City of Portland, Maine - Building or Use Permit Application

Permit No: 06-1130	Issue Date: PERMIT ISSUED AUG 18	CBL: 24 C013001
-----------------------	---	--------------------

Proposed Use: Single Family Home- link addition to correct roofing problem between house and barn & porch addition	Proposed Project Description: link addition to correct roofing problem between house and barn & porch addition
--	--

1
1/4"=1'-0"

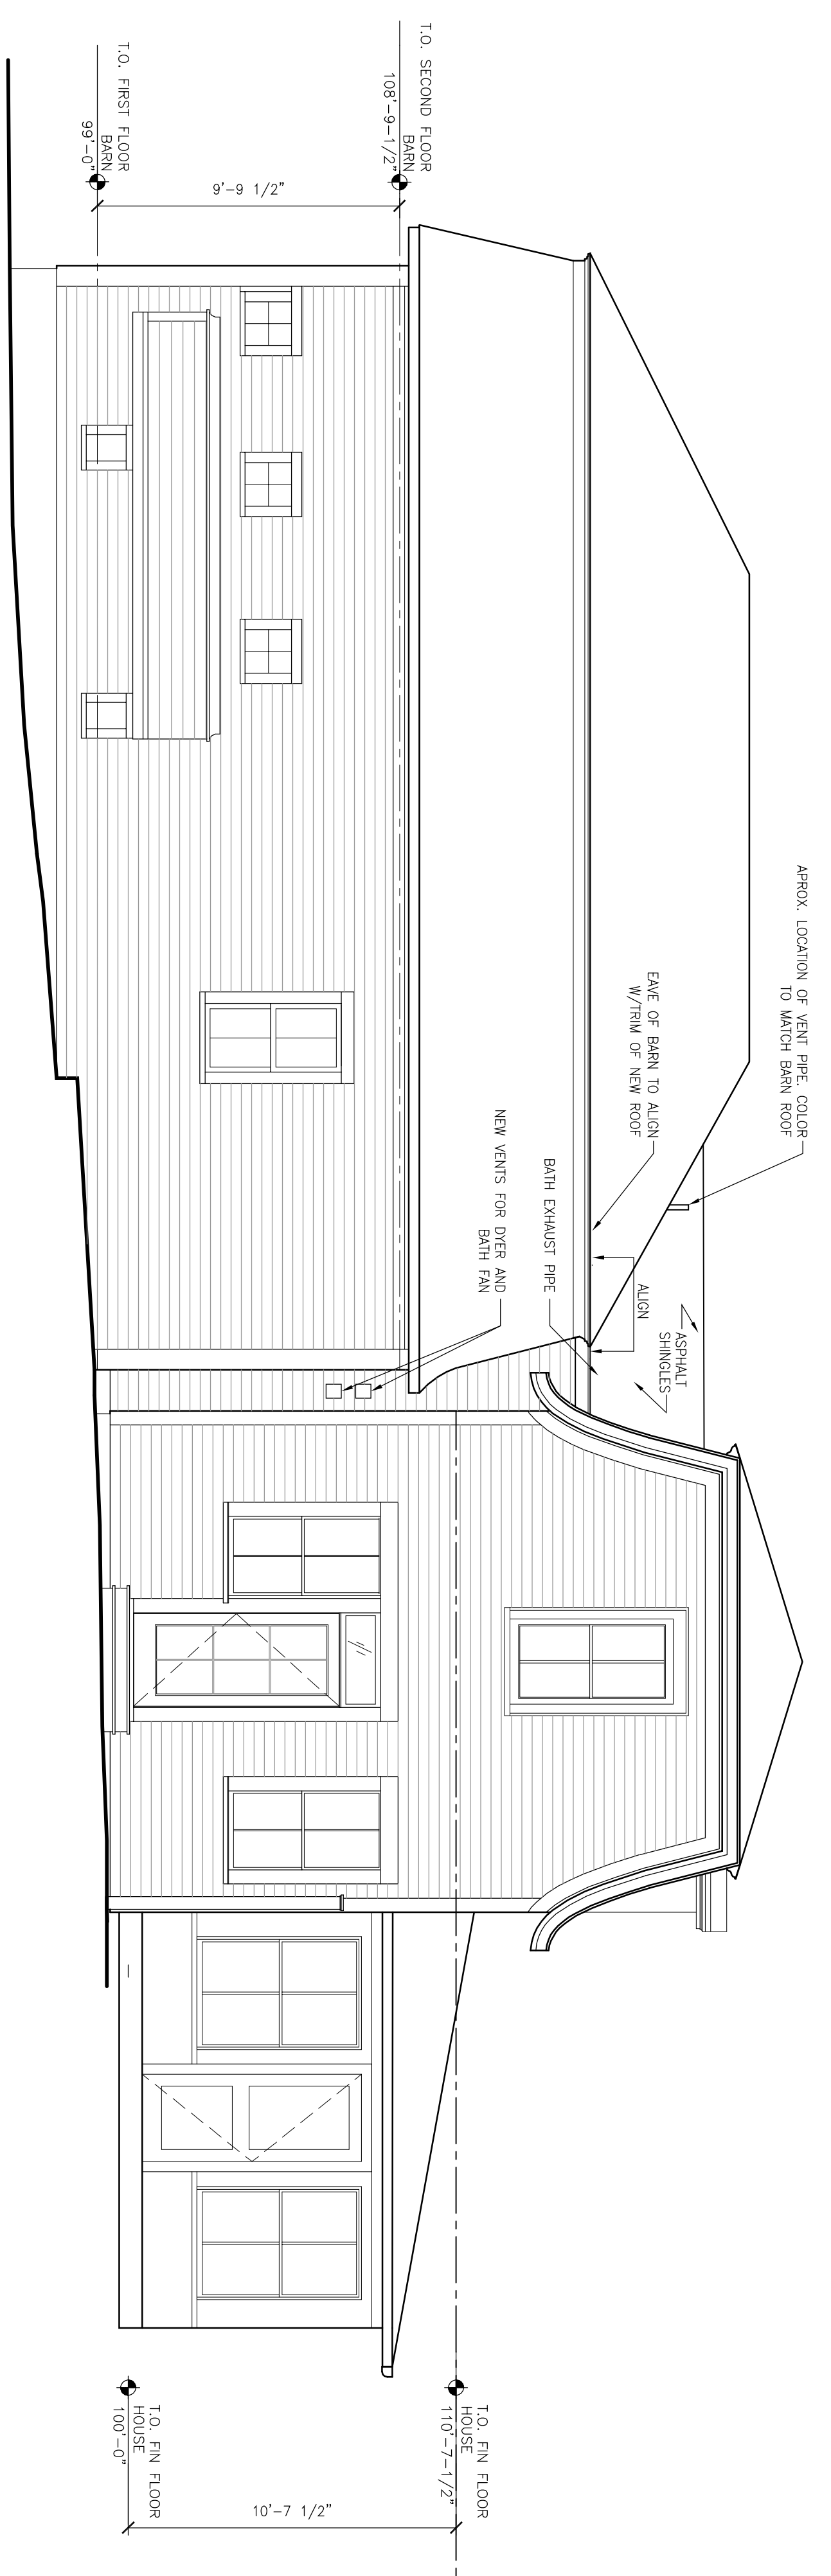
Dept: Building	Status: Approved with Conditions	Reviewer: Residential Plan Review	Approval Date: 08/18/2006
Note:			Ok to Issue: <input checked="" type="checkbox"/>
1) Guards must have openings less than 4 inches, applicant will furnish final guard protection plan for approval for the porch prior to installation of same.
